KIRKLEES METROPOLITAN COUNCIL INVESTMENT & REGENERATION SERVICE

DELEGATED DECISION TO DETERMINE PLANNING APPLICATIONS

Reference No:	2024/62/90637/E
Site Address:	8, Westfield Court, Mirfield, WF14 9PT
Description:	Demolition of existing garage and erection of two storey side and single storey side and rear extensions with dropped kerb and associated alterations
Recommending Officer:	Edward Cheseldine

DECISION - REFUSED

Proposed Rear Elevation - South West

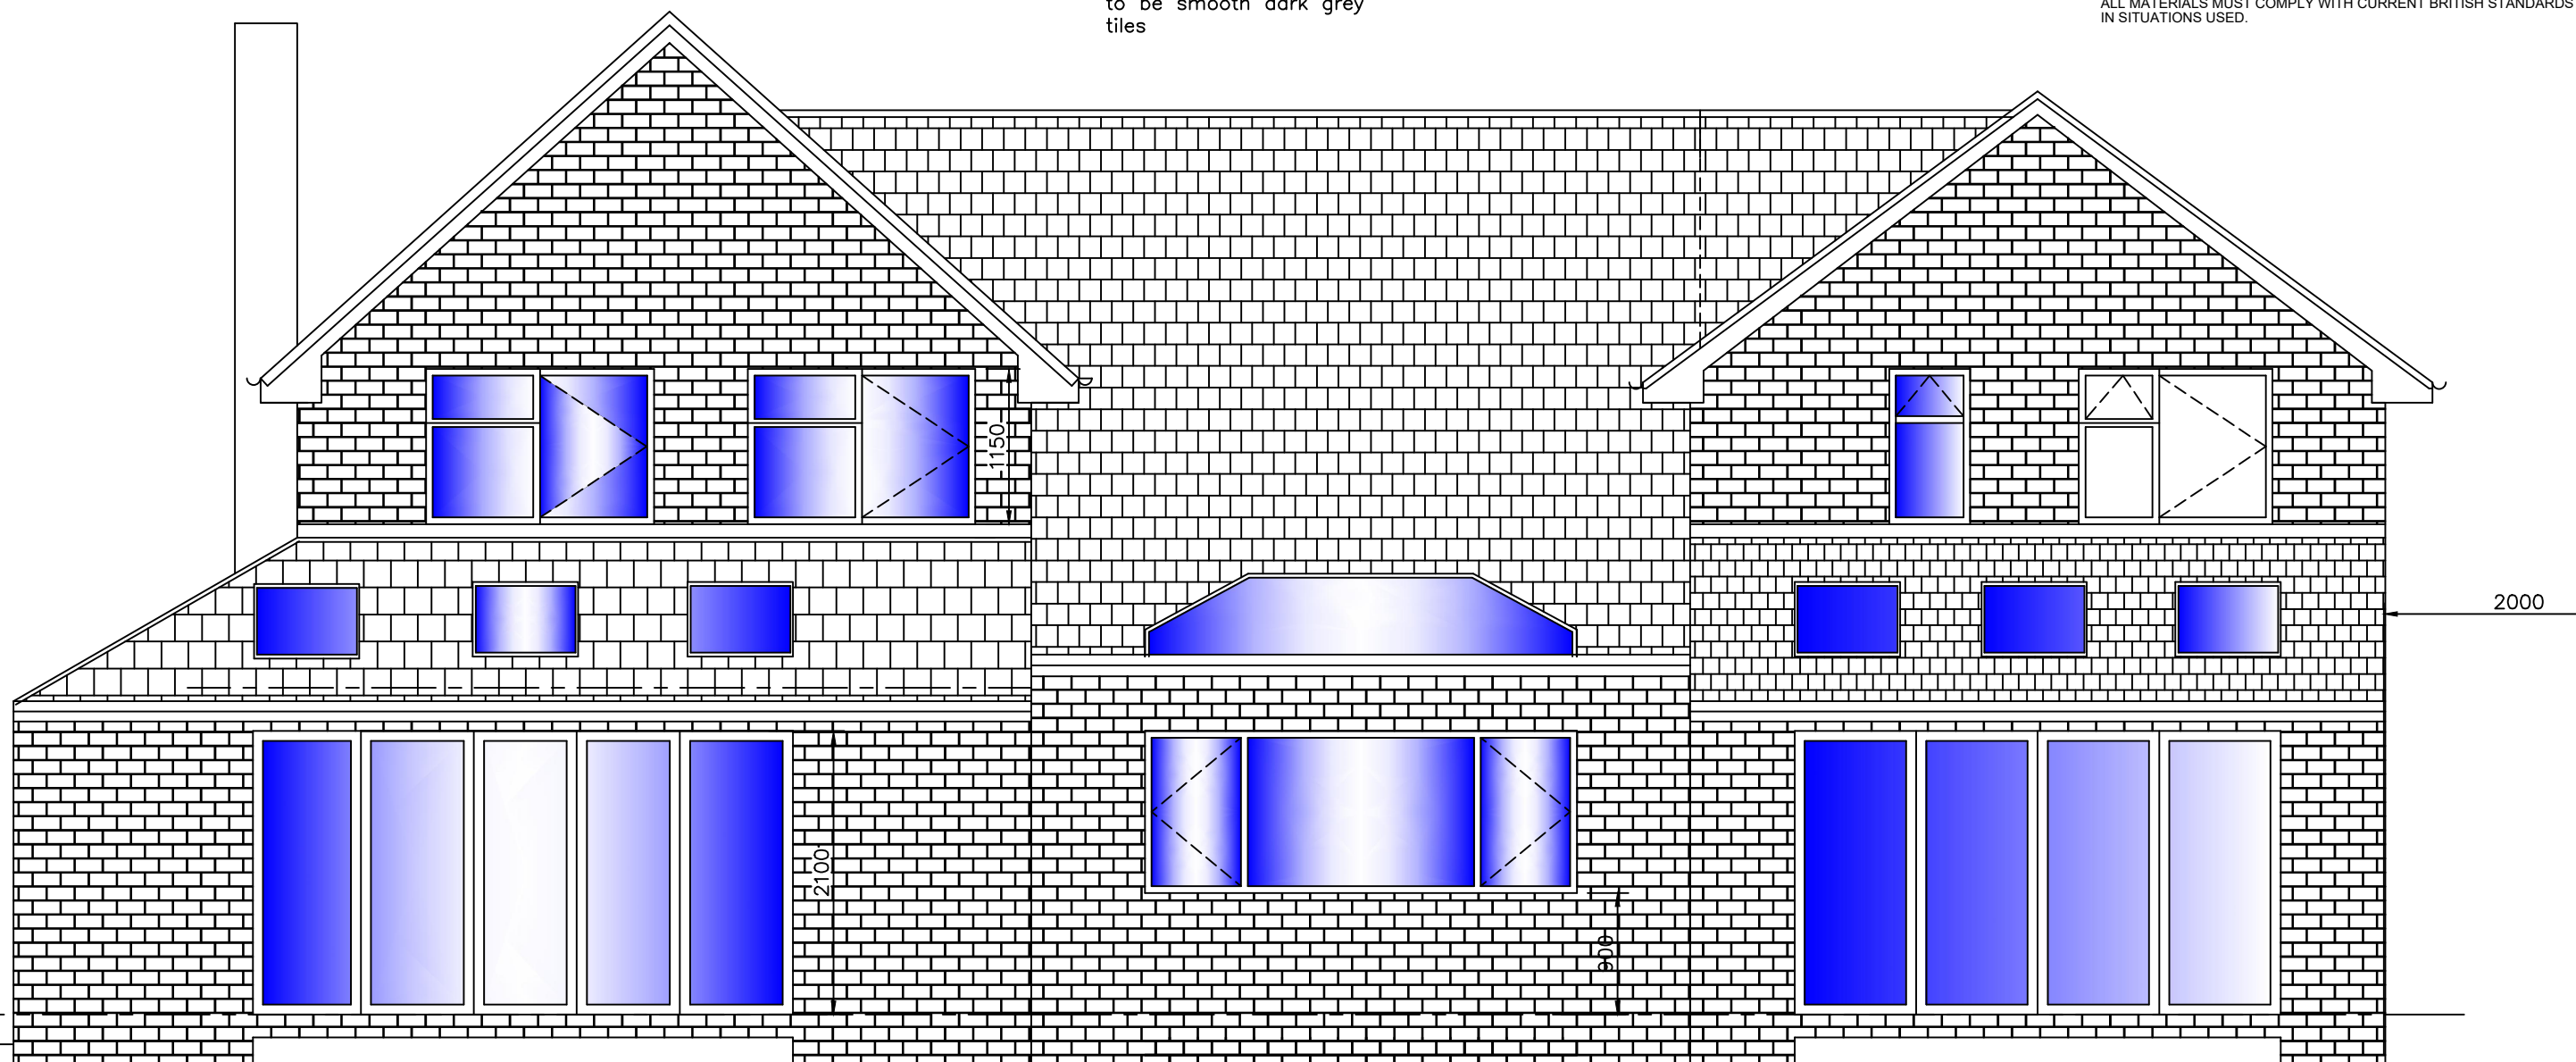
The increase in footprint is significant. In comparison to its immediate neighbours, the scale of the dwelling is considerable, it would project rearwards by ~3.70m, have infill extensions and form additional vertical massing to these properties which further departs it from the existing building group.

In terms of privacy, there will be new openings in the rear of the property, including on the first-floor level. These properties are ~25.00m away from the rear single storey extension. Although there will be additional windows facing this direction, the distance will mitigate any impact to privacy. Additionally, there are already first-floor windows on the property facing this direction.

Proposed First Floor Plan

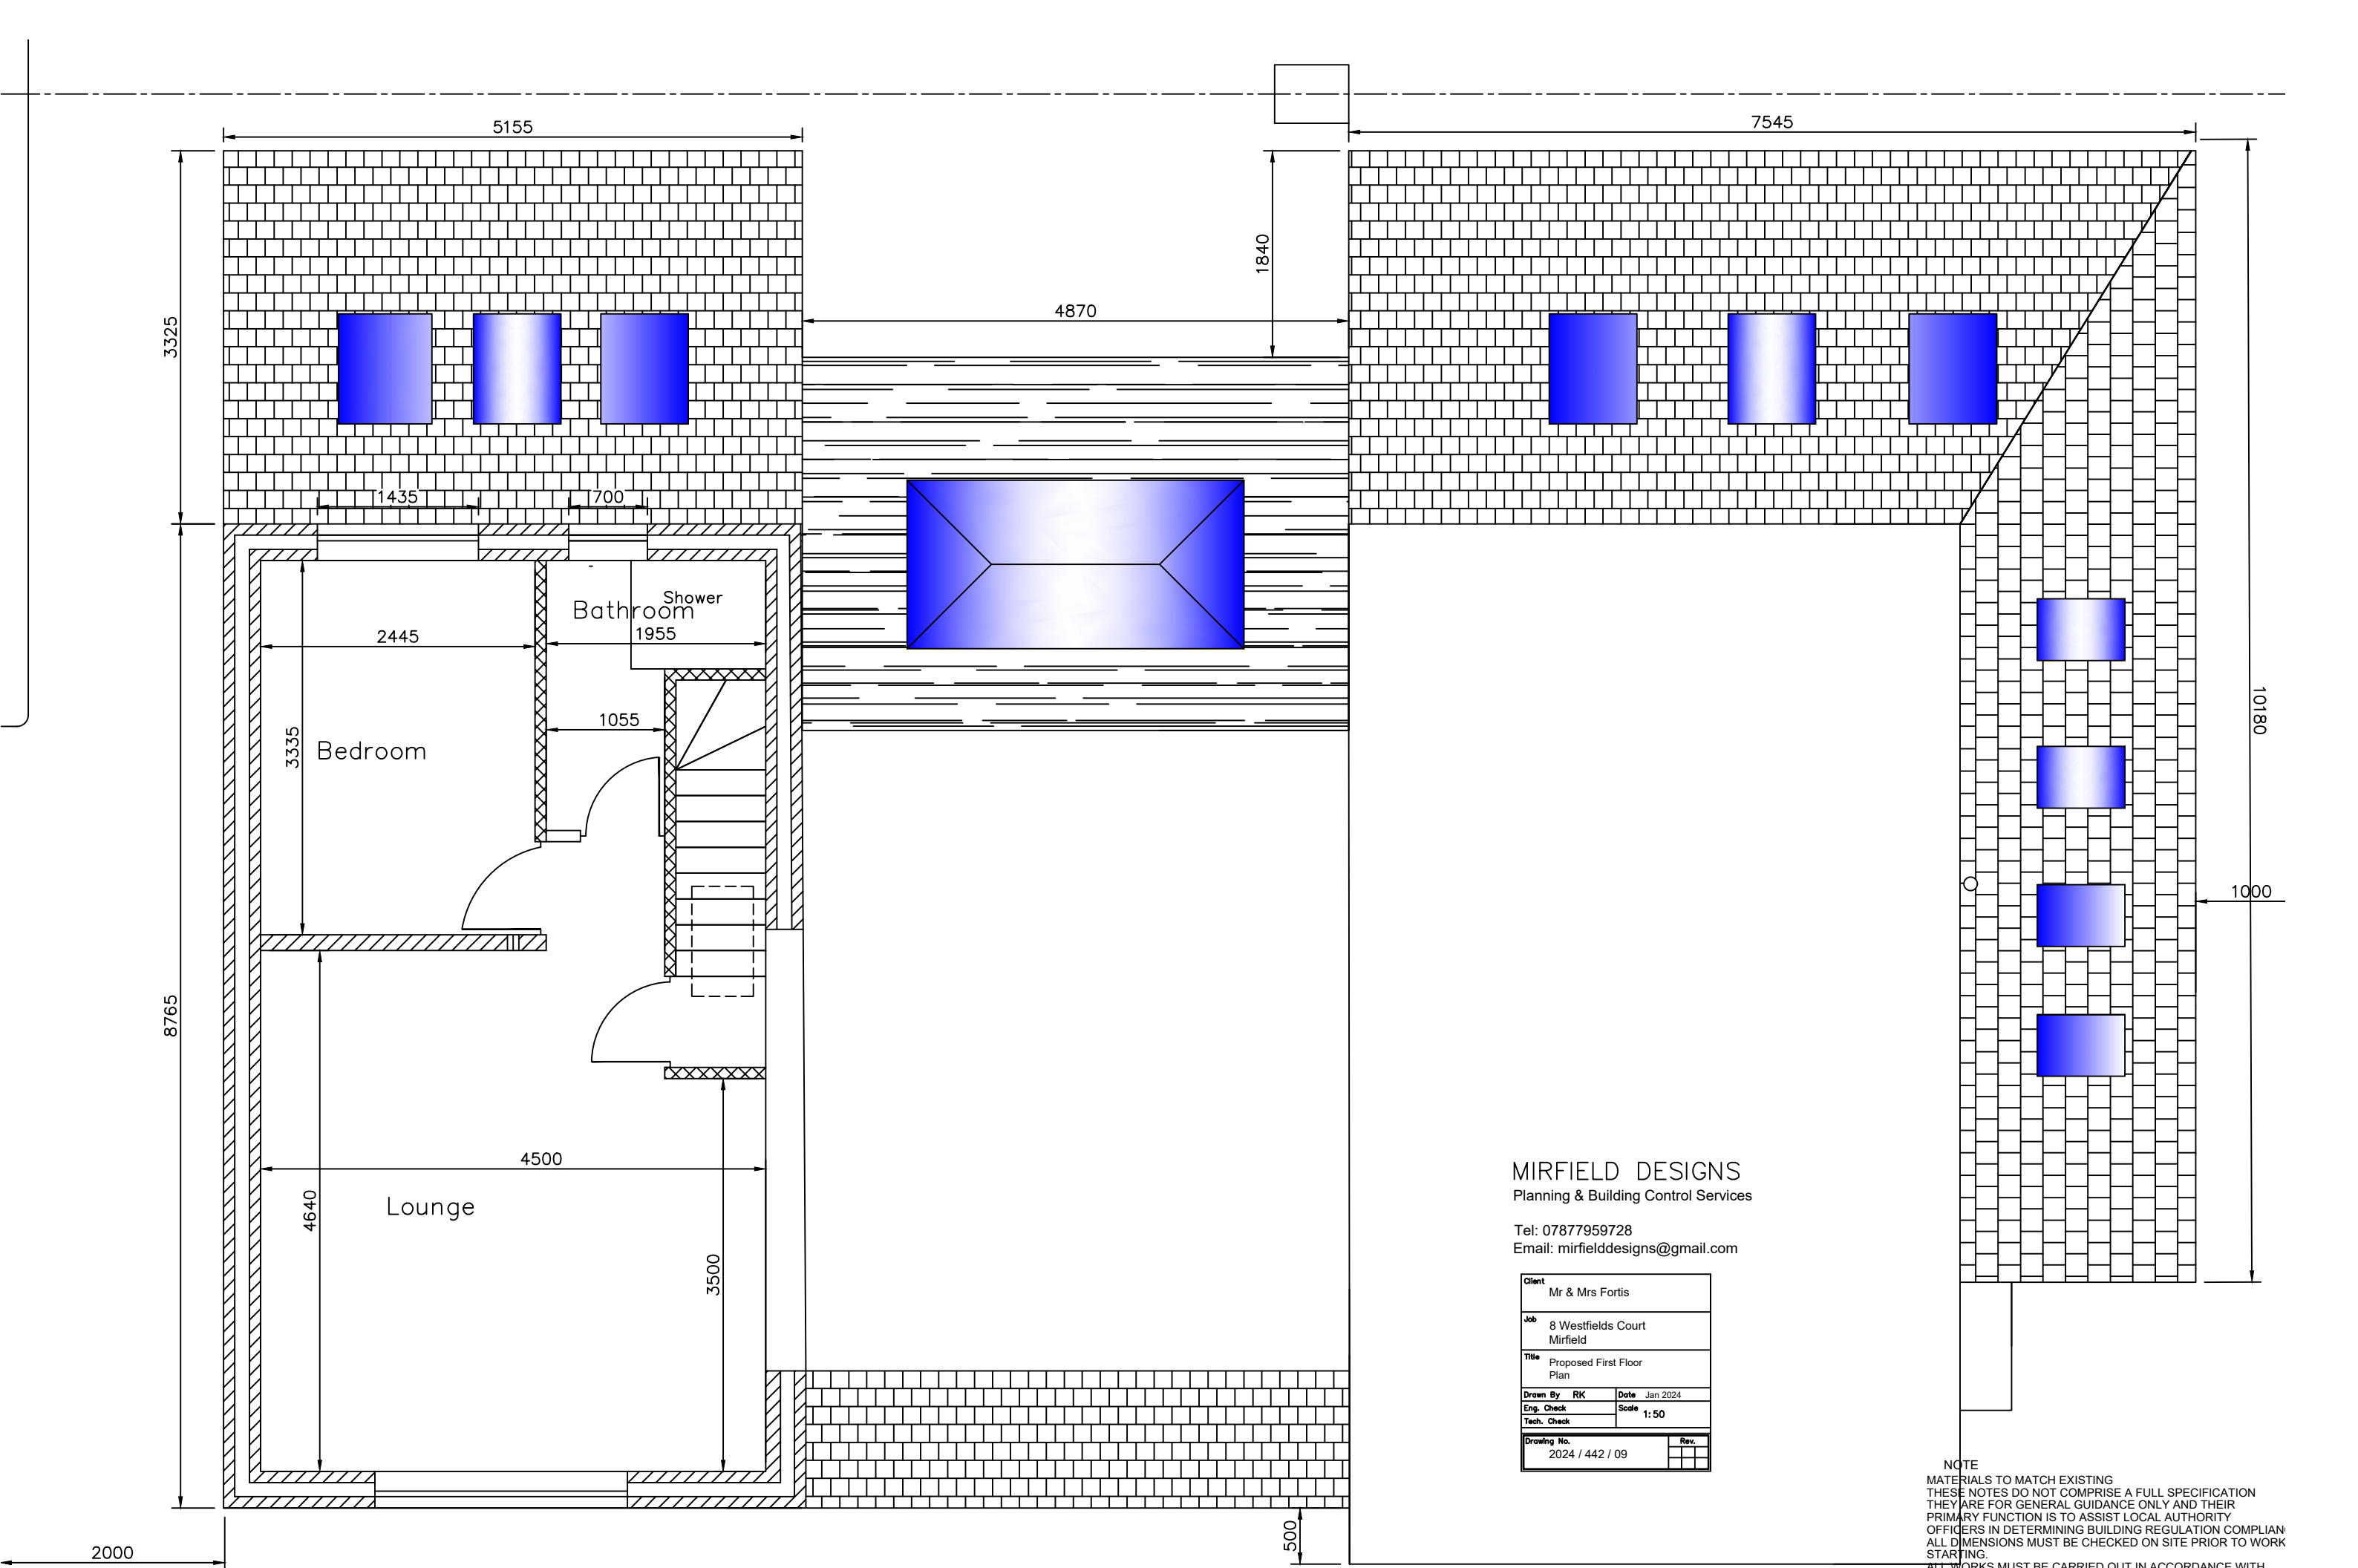
In terms of an overbearing impact, loss of light or outlook, there will be a significant first-floor mass increase on this elevation. A 2.00m space will be retained to the side. The eaves height of this elevation will be ~4.70m. Whilst this is a great increase, the side space at No. 8 serves as access to the rear and is not functionable outdoor amenity space. The rearward projection will be formed of a single storey section, therefore there will not be a loss of light to habitable rooms, loss of outlook or an overbearing impact. There may be a slight loss of sun in the afternoon, however the change in ground height and pitched roofs will mitigate against this.
